Our Ref: TR040011

Planning Act 2008 – Section 51

Application by North Somerset District Council for an Order Granting Development Consent for the Portishead Branch Line – MetroWest Phase 1

Advice following issue of decision to accept the application for Examination

Appendix N Part 4 of 8, Simulated River Avon flood maps – tidal events, 2115

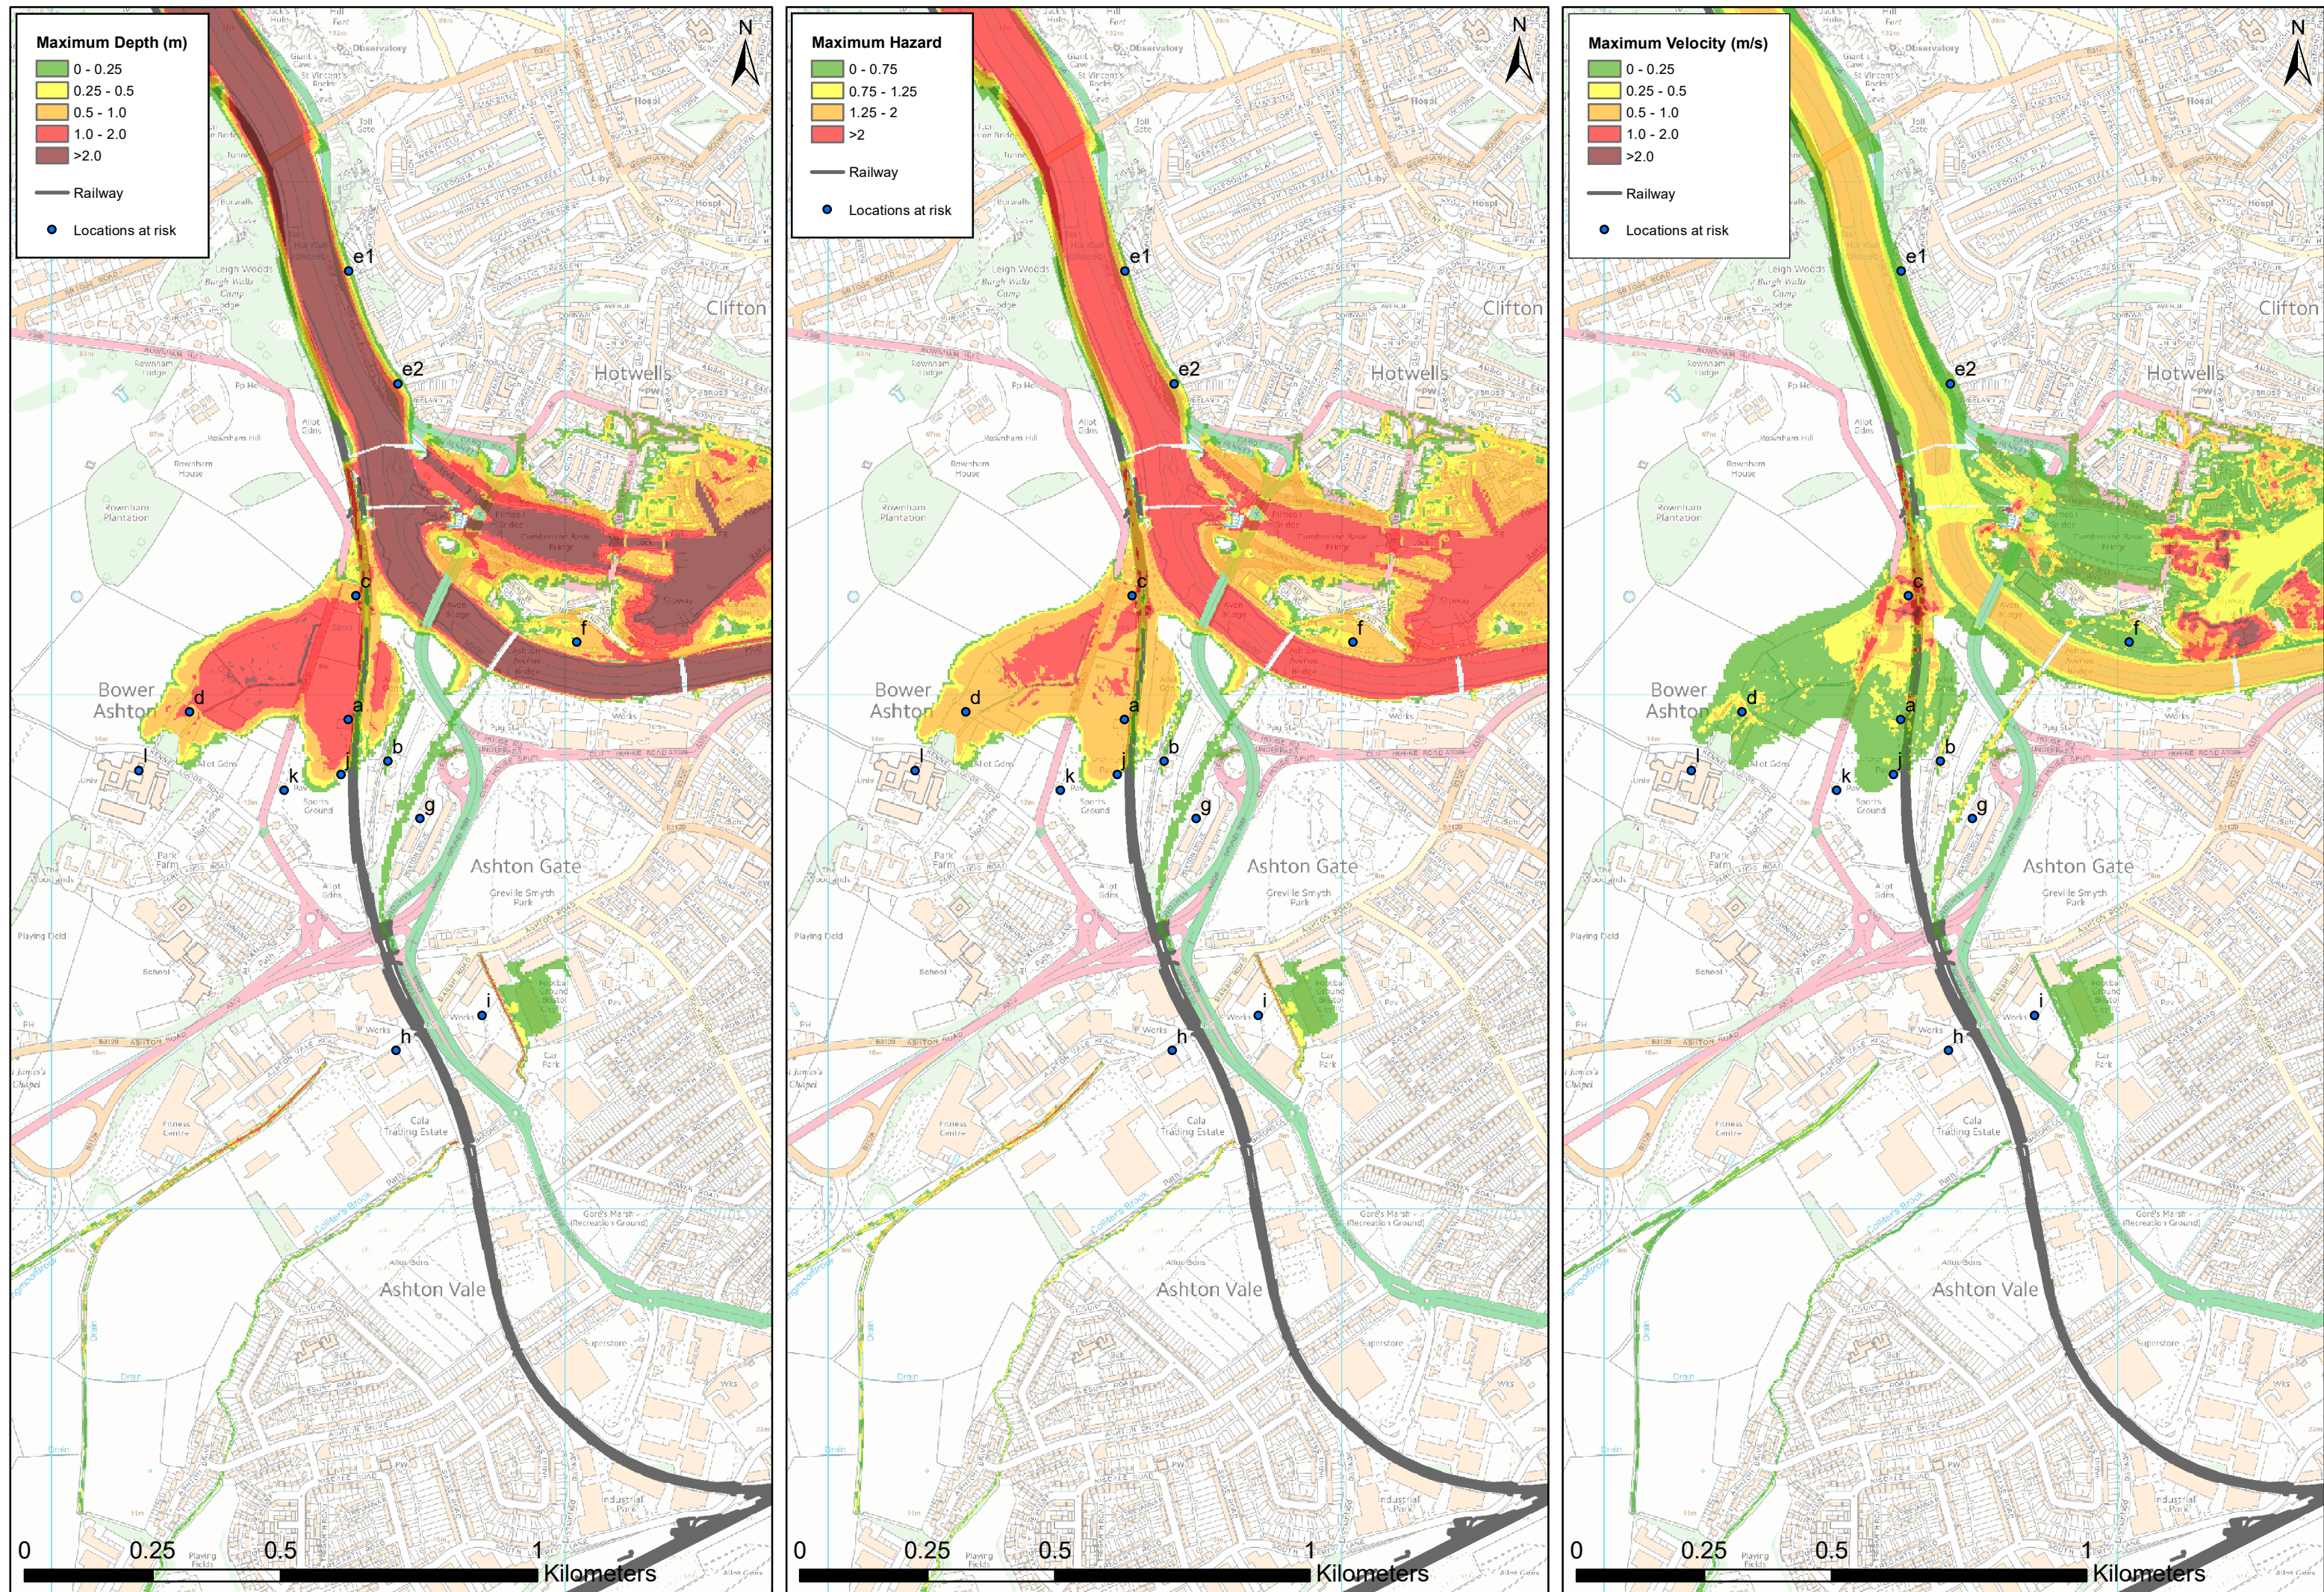
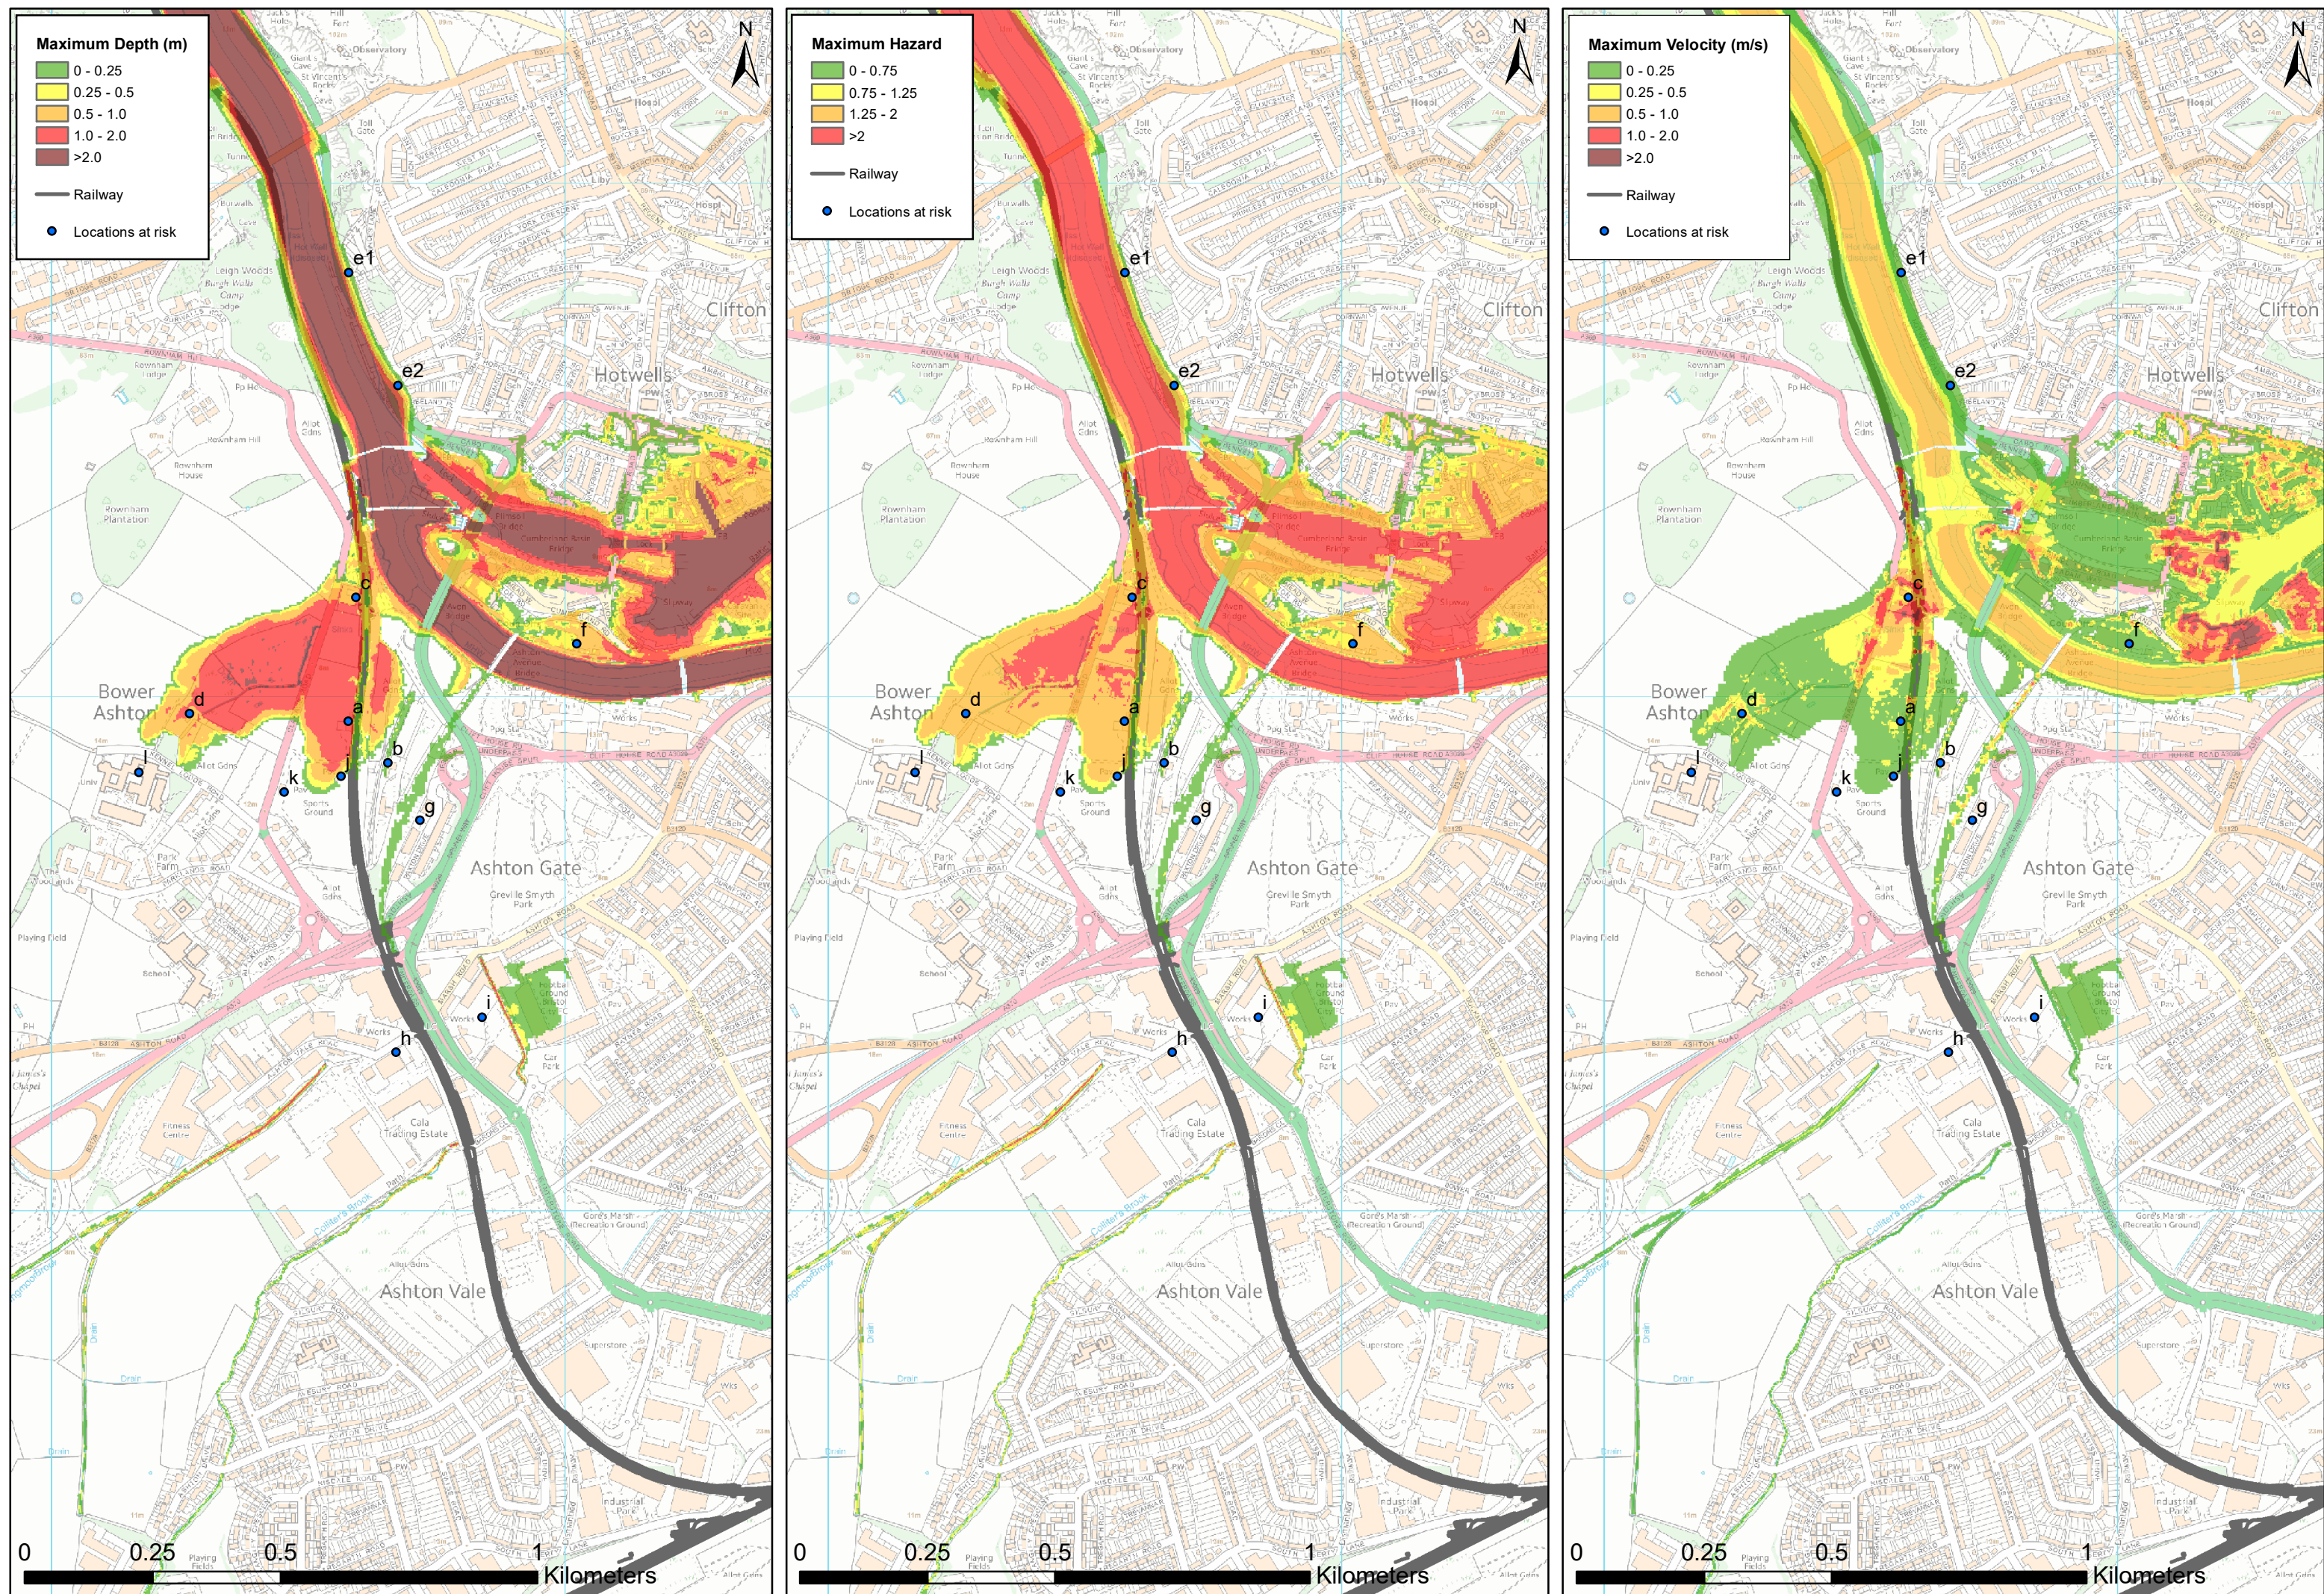
At Bower Ashton - the simulation of impacts from River Avon tidal flooding indicates that this section of the operational NSIP would experience tidal flood events once every 5 to 10 years for the assessment year (taken to be 2015) and more than once a year on average in the future (scenarios 2075 and 2115) (taking into account climate change, including sea level rise, into consideration). In preparation for the examination the Inspectorate seeks to understand the extent to which the application of the revised climate change allowances may (or may not) affect the findings in this regard. In particular, whether such detail would result in anticipated flood events at more frequent intervals and at earlier points in the design life of the Proposed Development.
